101 - Proposed Surface Water Drainage

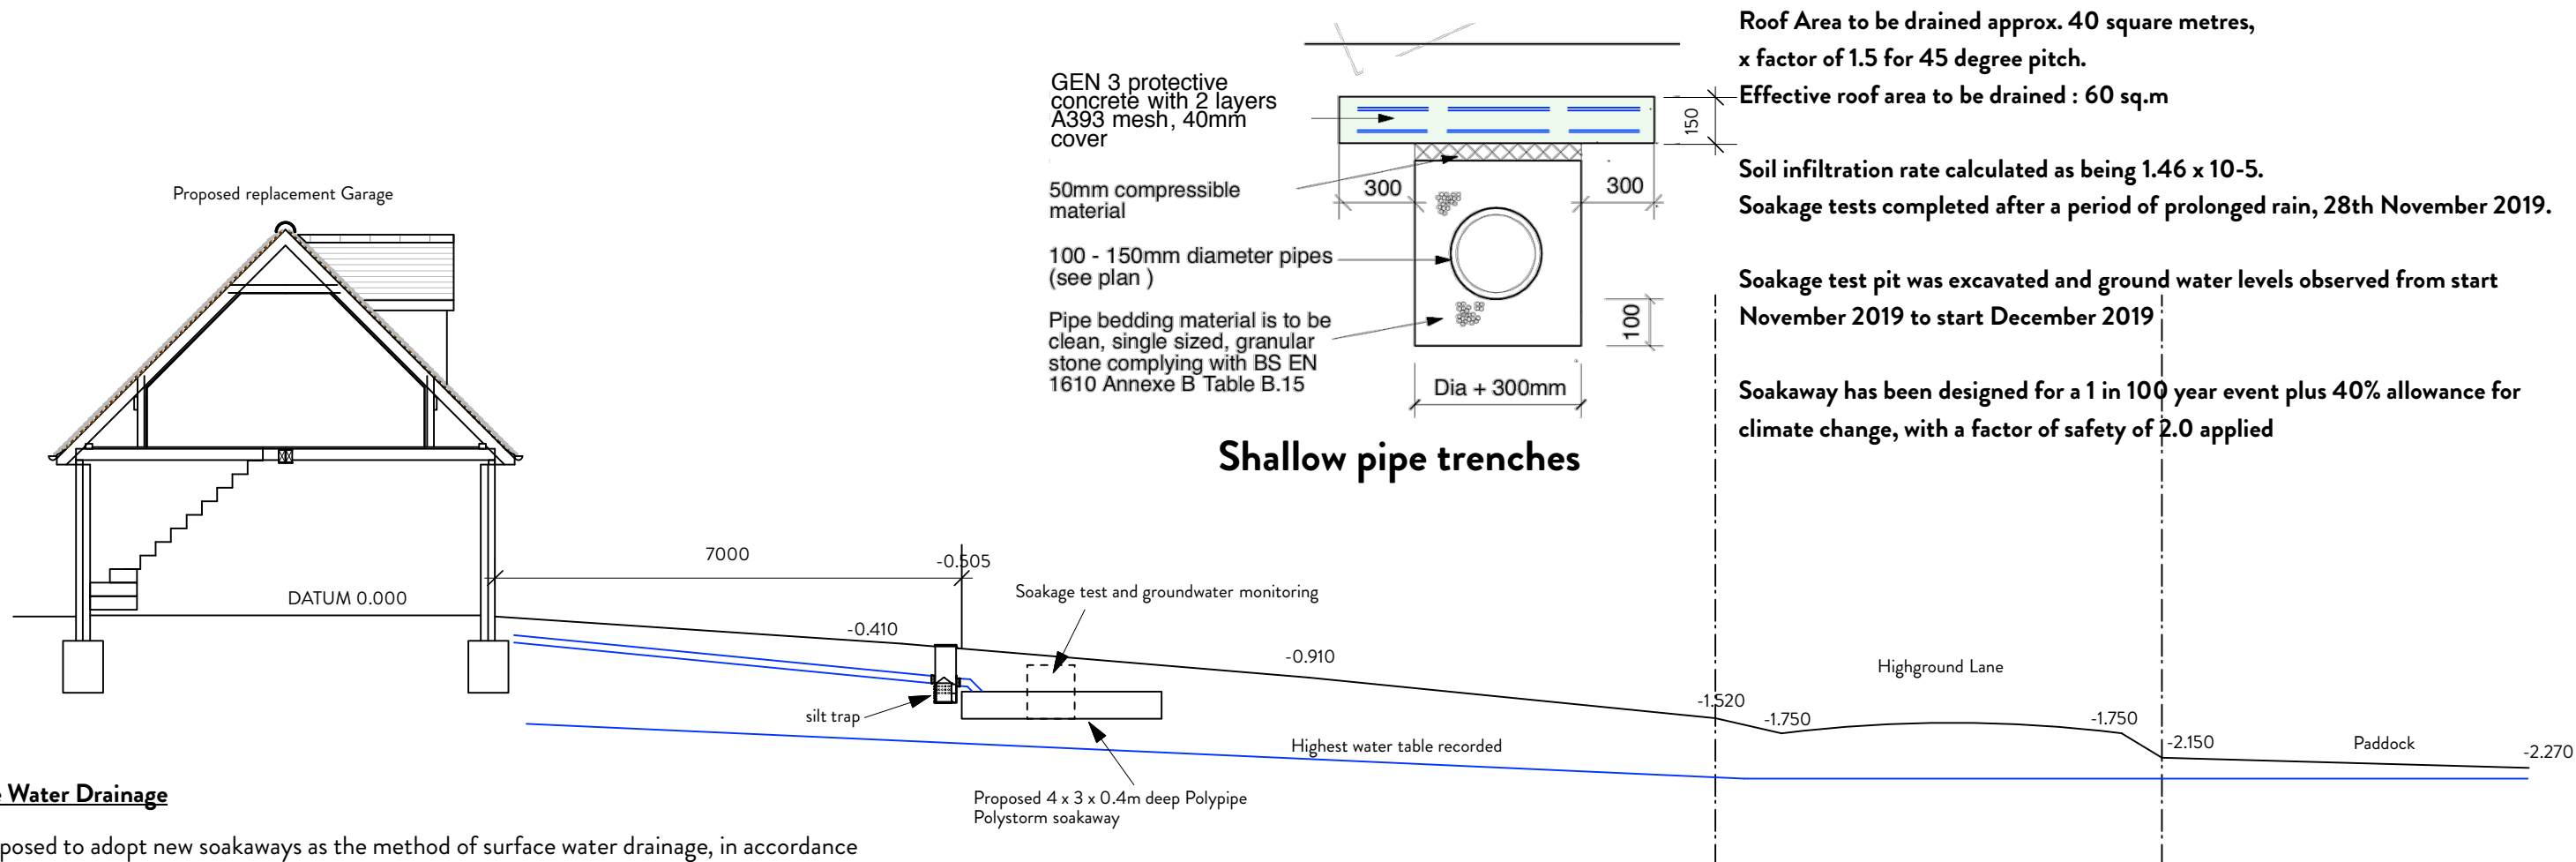
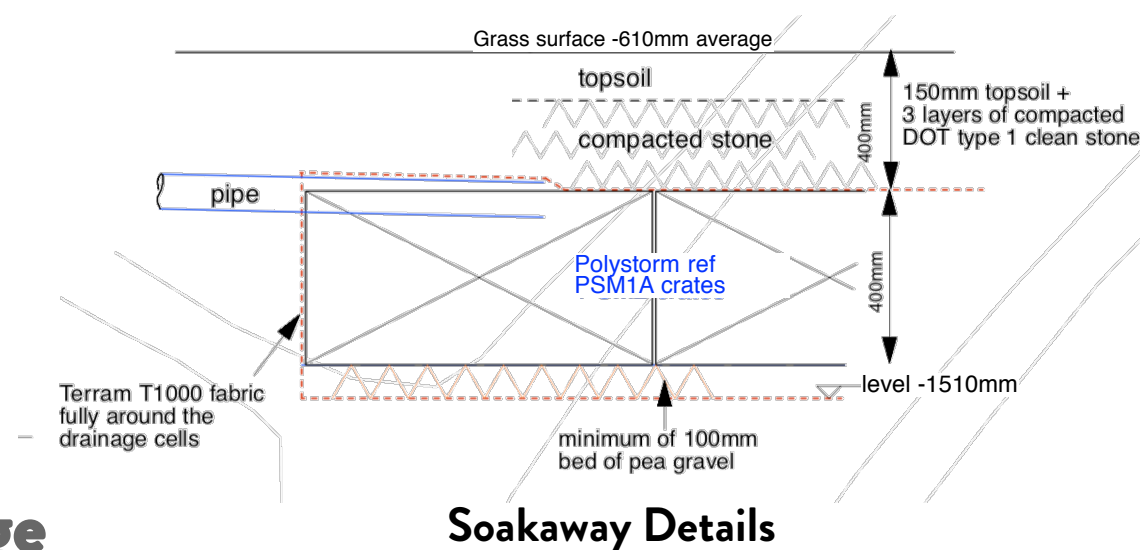
1. We do not normally approve schemes which account infiltration through the base of a soakaway in their design calculations. This is in accordance with BRE365 and due to the risk of silt reducing the infiltration rate. The applicant has included a silt trap so could make an argument for going through the base, however this will mean delegating the decision to the Principle Drainage Engineer which will cause further delays to the process. Alternatively they can adjust the calculations to show an 'Infiltration Coefficient Base' as zero.
2. Please show an indication of the location of the silt trap on the Proposed Section.
3. Please include a construction detail for the pipe bed and surround (I appreciate they have got a description but point 11 of the guidance notes states that this is required).

As a minimum (and following a brief review) we would require further detail of the groundwater monitoring and infiltration testing. I understand that this has been completed, however the results have not been supplied.

In addition, the soakaway needs to be designed for up to 1 in 100 year **+40%** and we would expect a silt trap and details of this to be shown. It is strongly advised that the applicant completes and submits a surface water drainage design checklist available at: <https://www.arun.gov.uk/download.cfm?doc=d9cm93ijm4n14067.pdf&ver=14313>

Further to my email this morning, the designers have now re-run the soakaway calculations with the base coefficient set to 0 and this has resulted in a larger soakaway, so please find attached revised drawings and calculations. Please disregard the drawings I sent this morning.

Apologies for the delay, it's taken a while for the revised drainage calculations to come back to me. Please find attached revised calculations, revised drawing 101, new plan 102, and completed checklist for the proposals.

Thank you for your email last week, sorry for my slow reply I was away. I will forward the required additional information to you this week, and updated calculations to show the 40% allowance rather than 30% which was designed.
